From: David Steele [REDACTED]
Sent: 27 February 2019 13:31
To: Simon Davis <Simon.Davis@arun.gov.uk>
Cc: Graham Stephens [REDACTED] Jonathan Pritchard
Subject: RE: BR/311/18/PL Chichester University

Current Scheme (6655) - December 20th 1044hrs

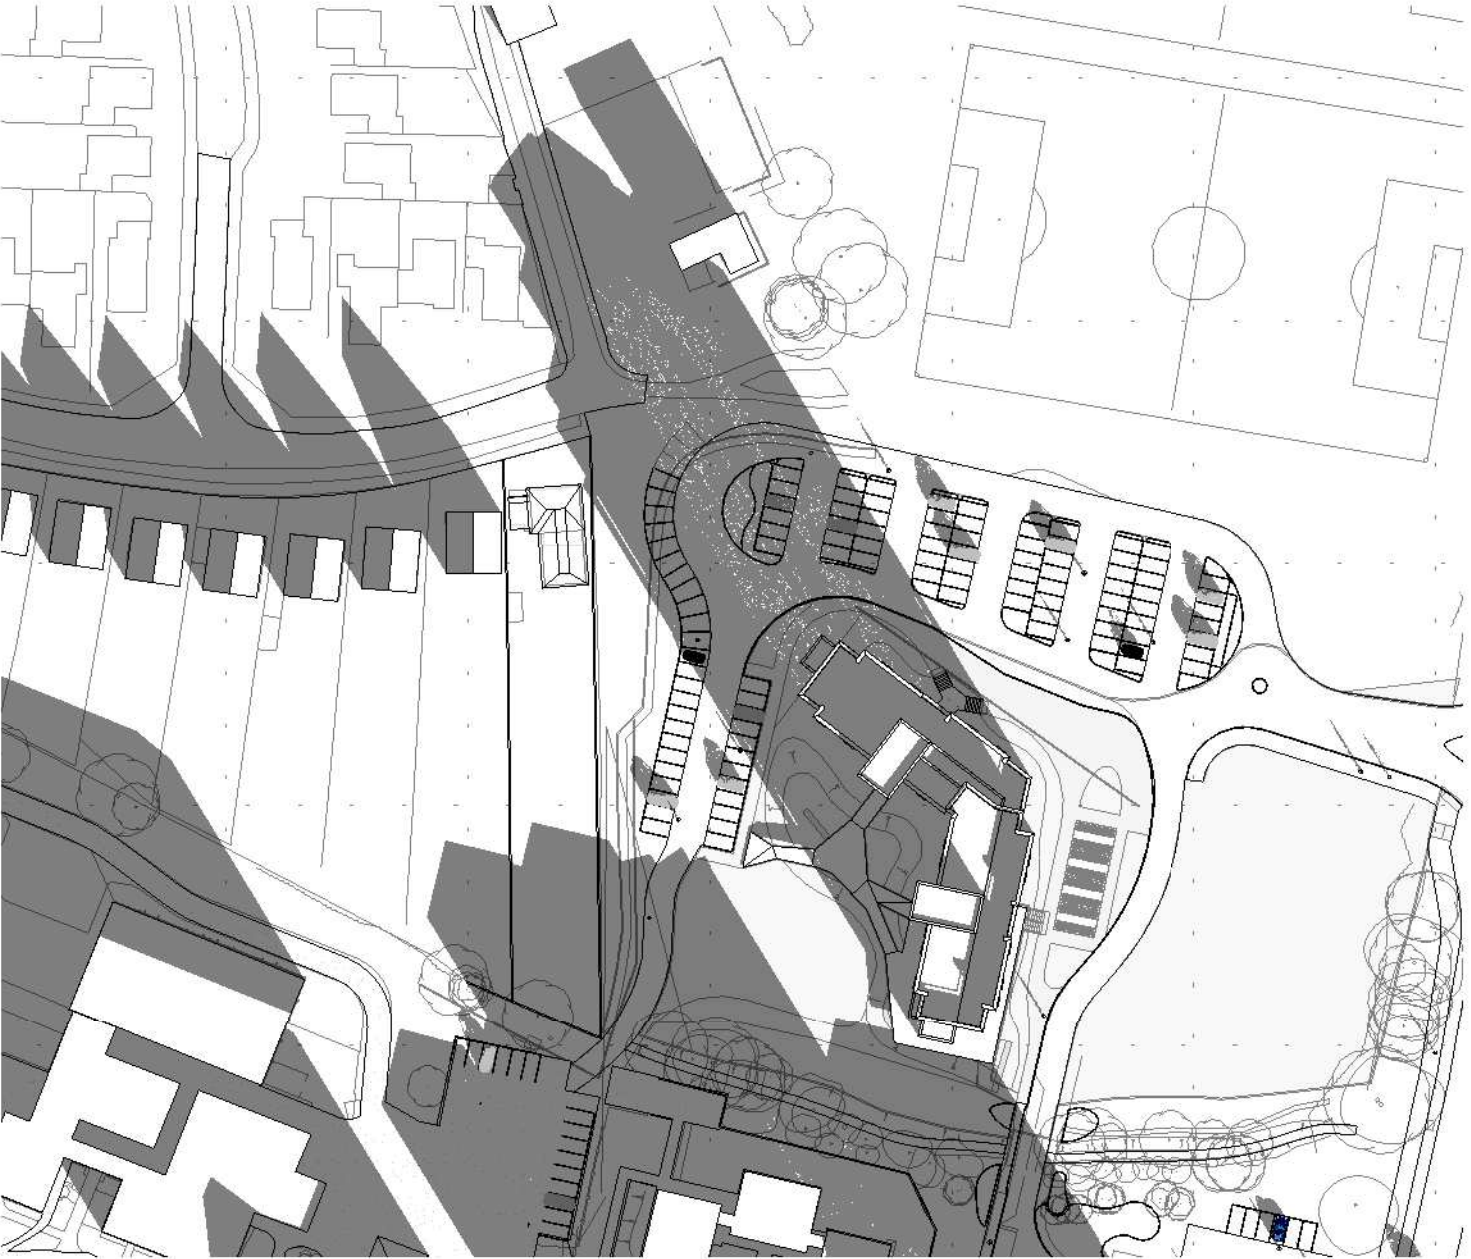
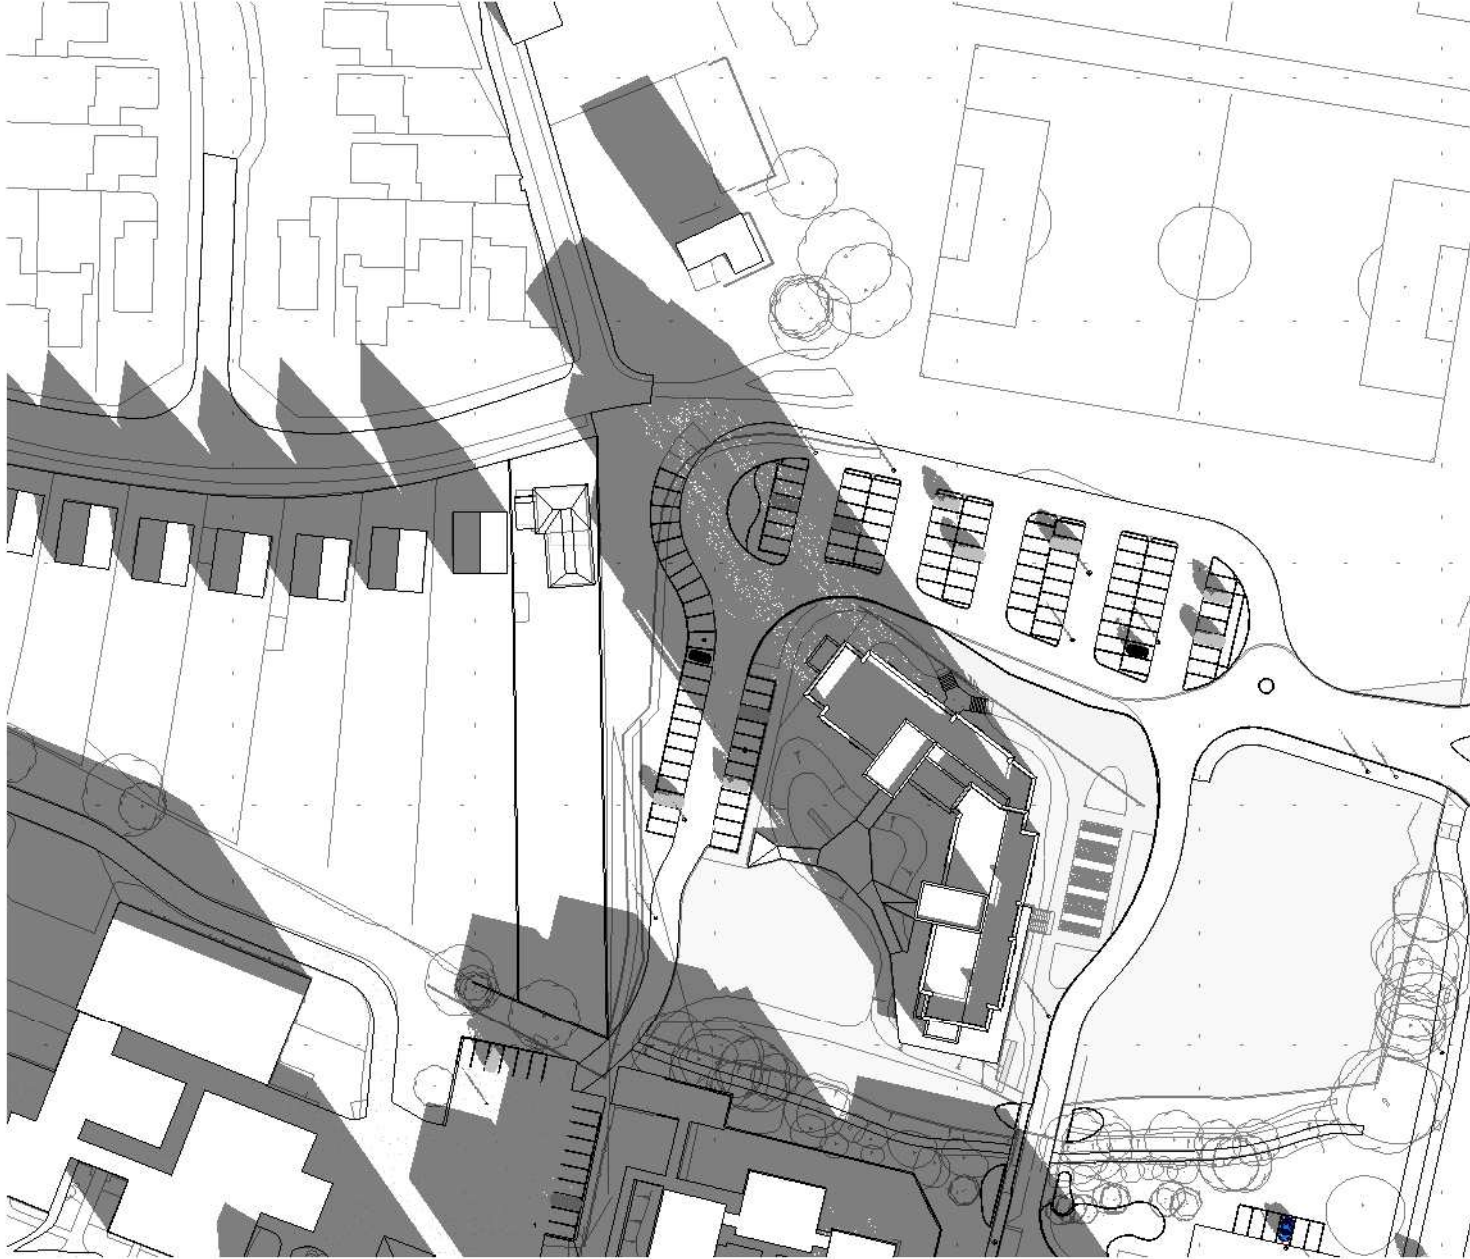
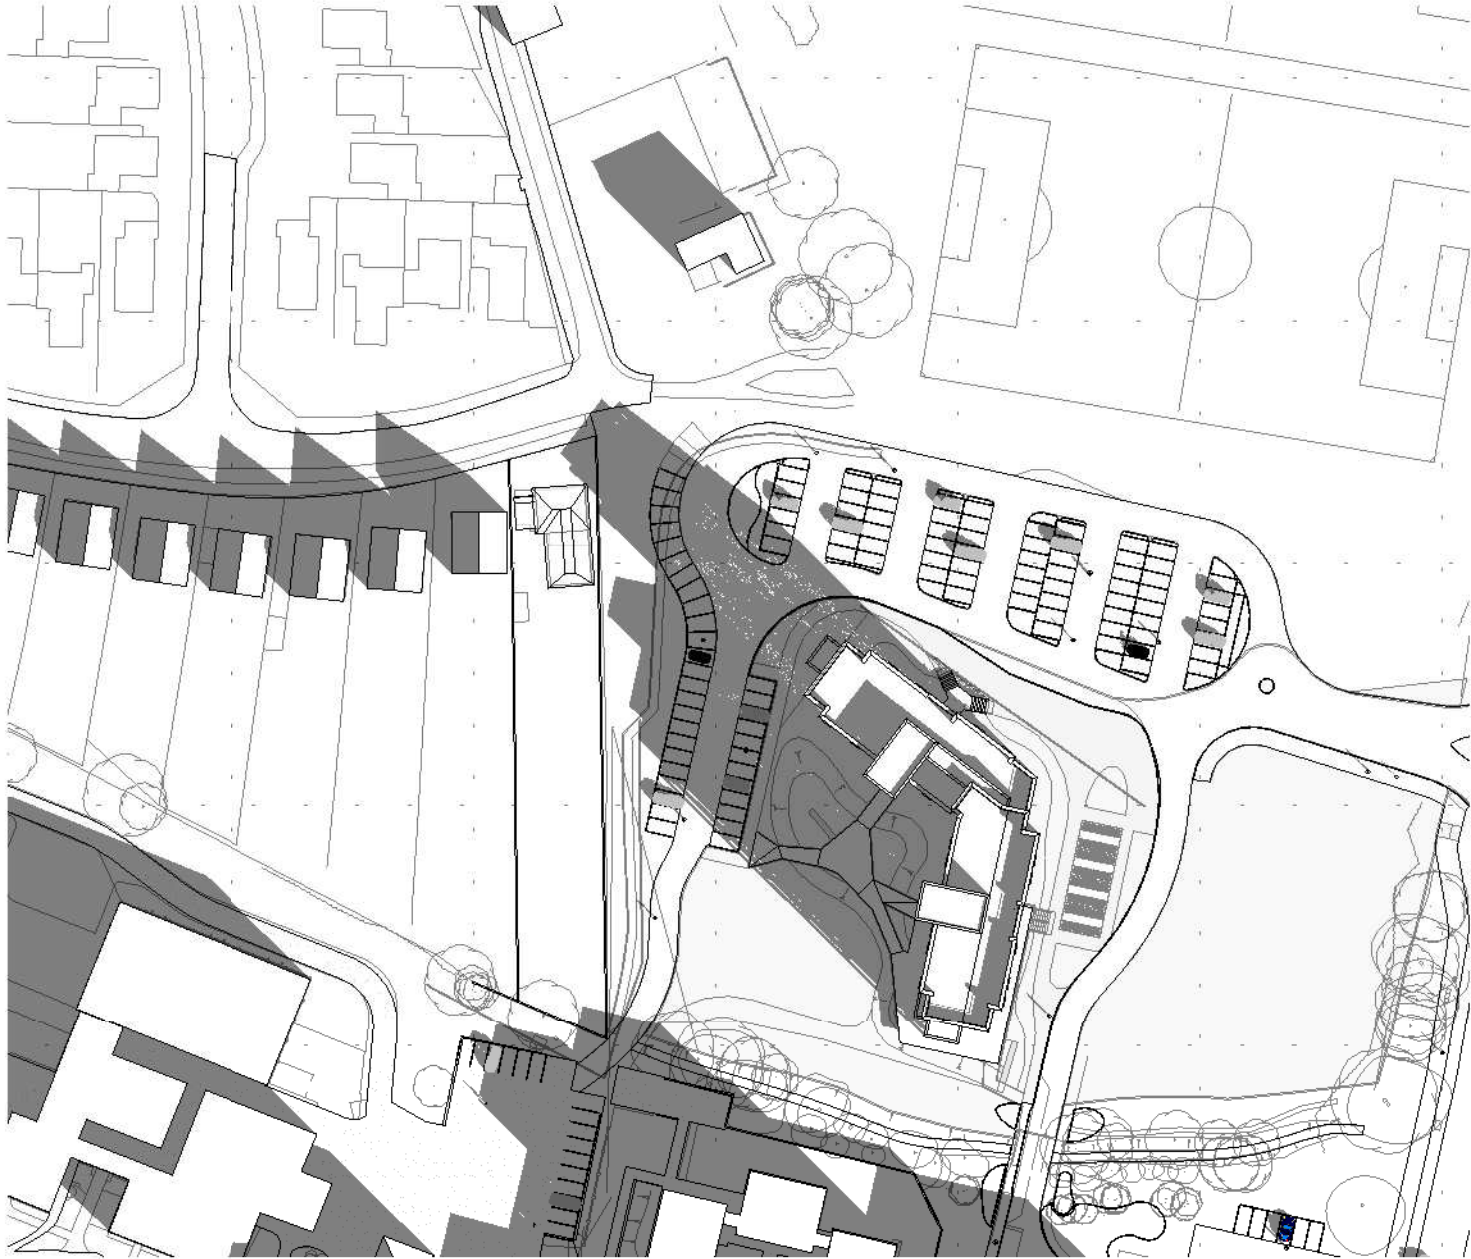
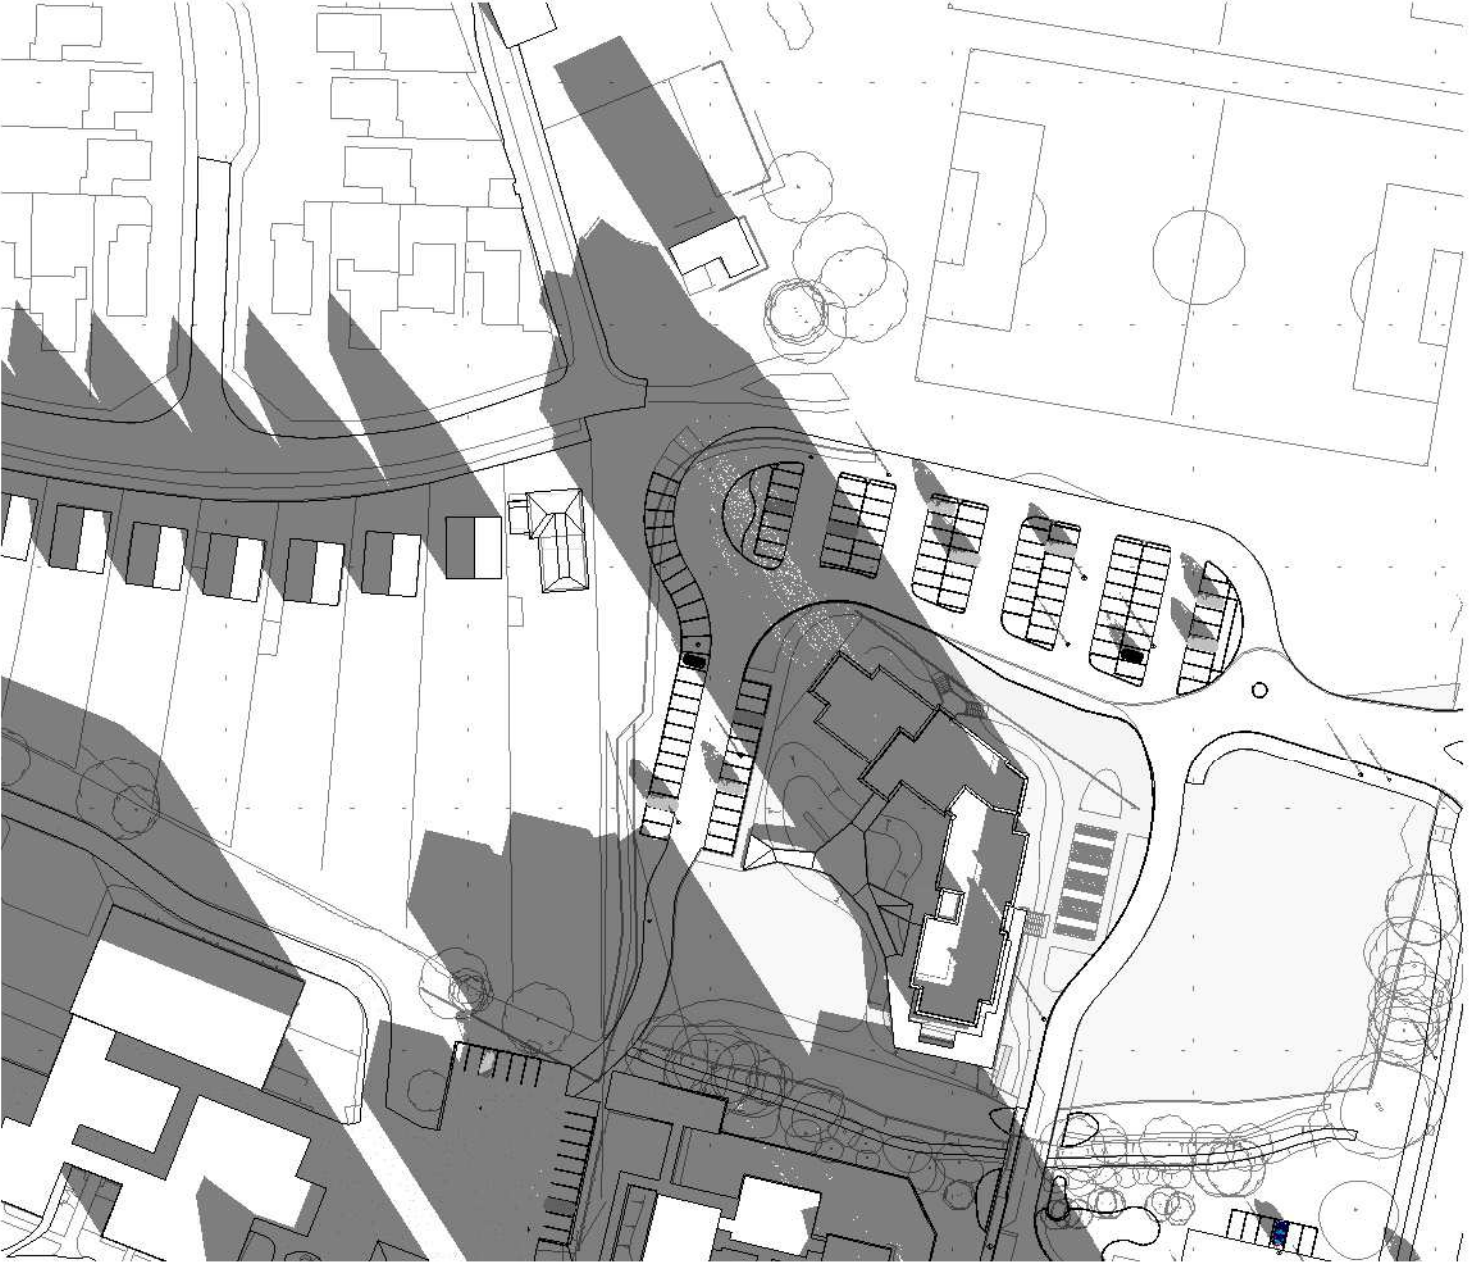
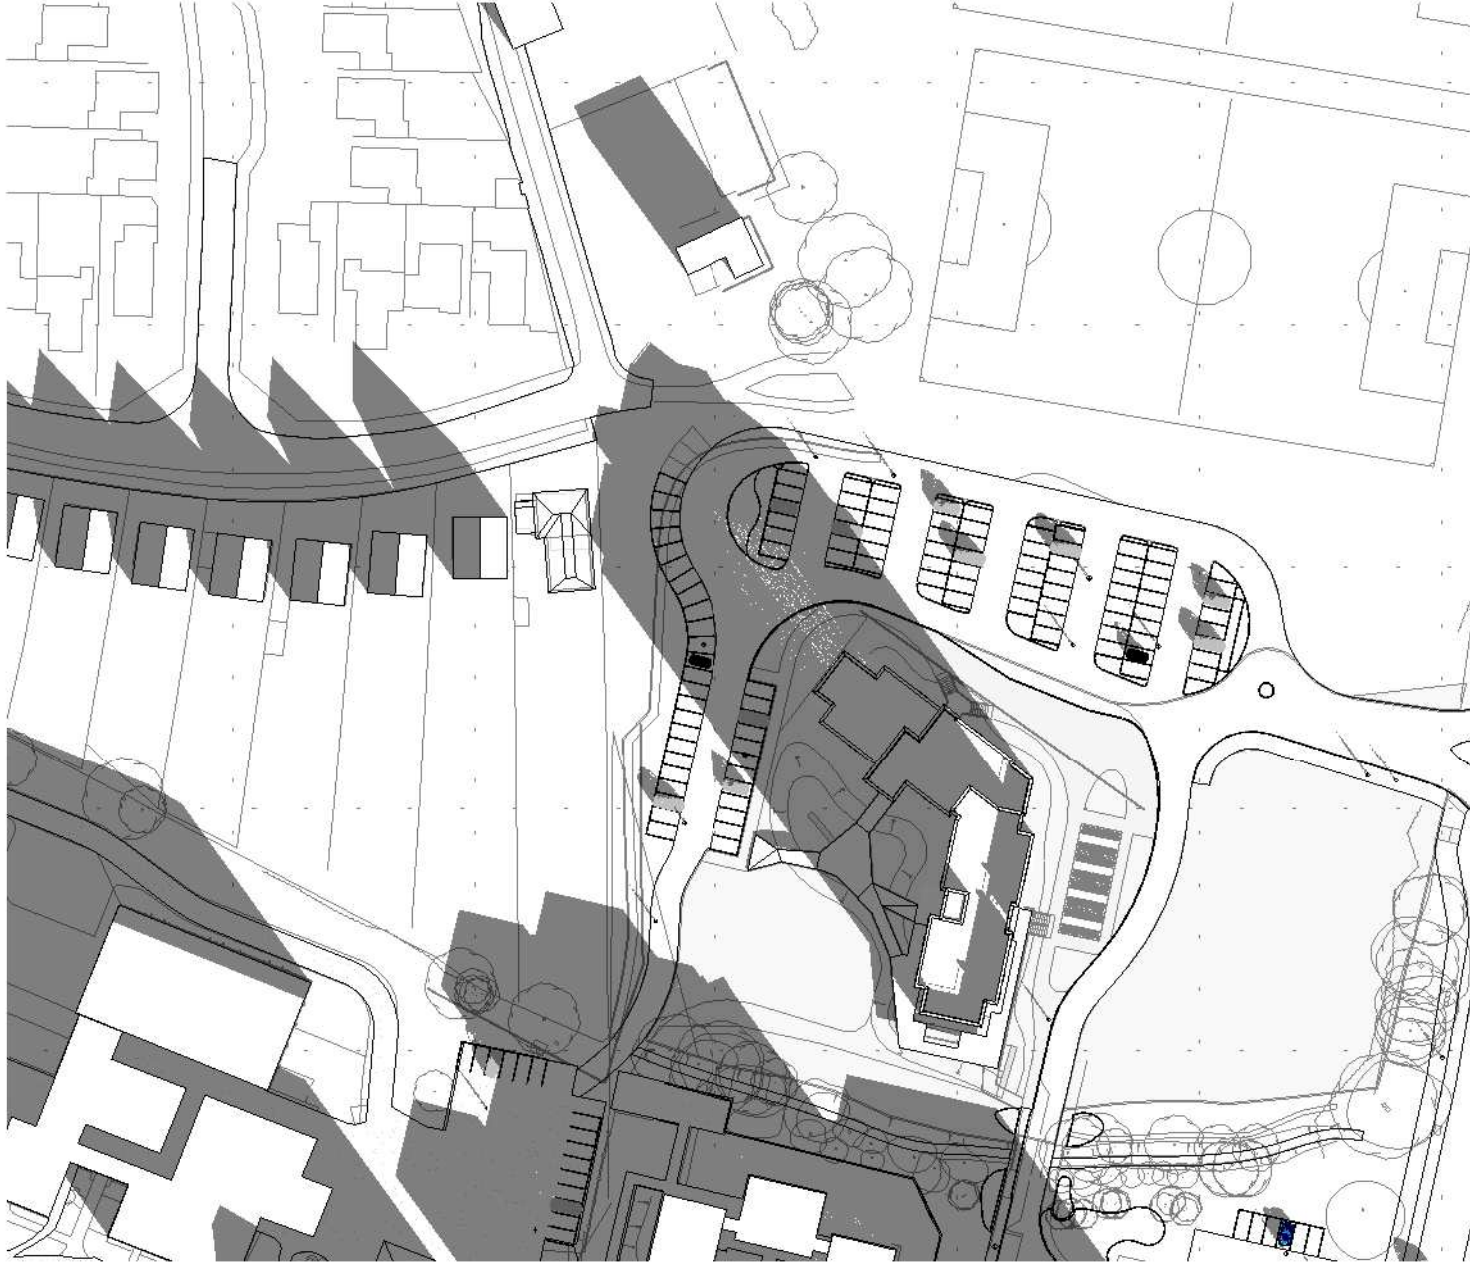
Your suggestion to reduce the end block of Block B from 5 storeys to 3 storeys highlights that this is the key area of concern and which we will seek to address.

It was discussed that on the previous application, the part of the building facing the Hook Lane dwellings was reduced from 6 storeys to 3/4 and this resulted in a reduction in bed spaces from 171 to 136. I read in the D&A that you have reverted back to the original height (albeit 5 not 6 storeys at this end) because you have re-assessed the shading analysis and found the impact it to be acceptable. However, having read the original report, I note that the request to lower the building was partly on grounds of shading and partly on grounds of an overbearing impact. I consider that the overbearing impact remains and therefore, I consider that this end of the building should be lowered. However, it may not be necessary to revert back to the 6643 approval – a 6653 scheme could be acceptable.

The attached plans also illustrate the application of the "25 degree rule" (BRE 'Site Layout Planning for Daylight and Sunlight' 2011) in the form of a section between the existing bungalow and proposed development. This highlights that the proposals would meet this test which assesses adequate daylight and outlook. Applying this rule of thumb to the outline scheme would also produce a similar result and highlights the acceptability of the proposals from a daylight and outlook perspective.

To assist in visualising this in context, we have today visited site to take a number of photographs from the University side of the boundary fence, setting out the corner of the proposed building and marking this with a 4m high staff, to ensure reasonable accuracy in determining its height. We have used this to show our building in context, and attach an image with the proposed building superimposed on the site photograph. For record purposes, the photographs were taken at 10:45am on 26th February. Notwithstanding the fact that there is a close boarded 1.8m high fence between this position and the bungalow behind, which will obscure most of this view, and the bungalow is set slightly further away than the origin of this photograph, in our opinion, this shows the scheme to be acceptable, both in terms of its massing and shadowing.
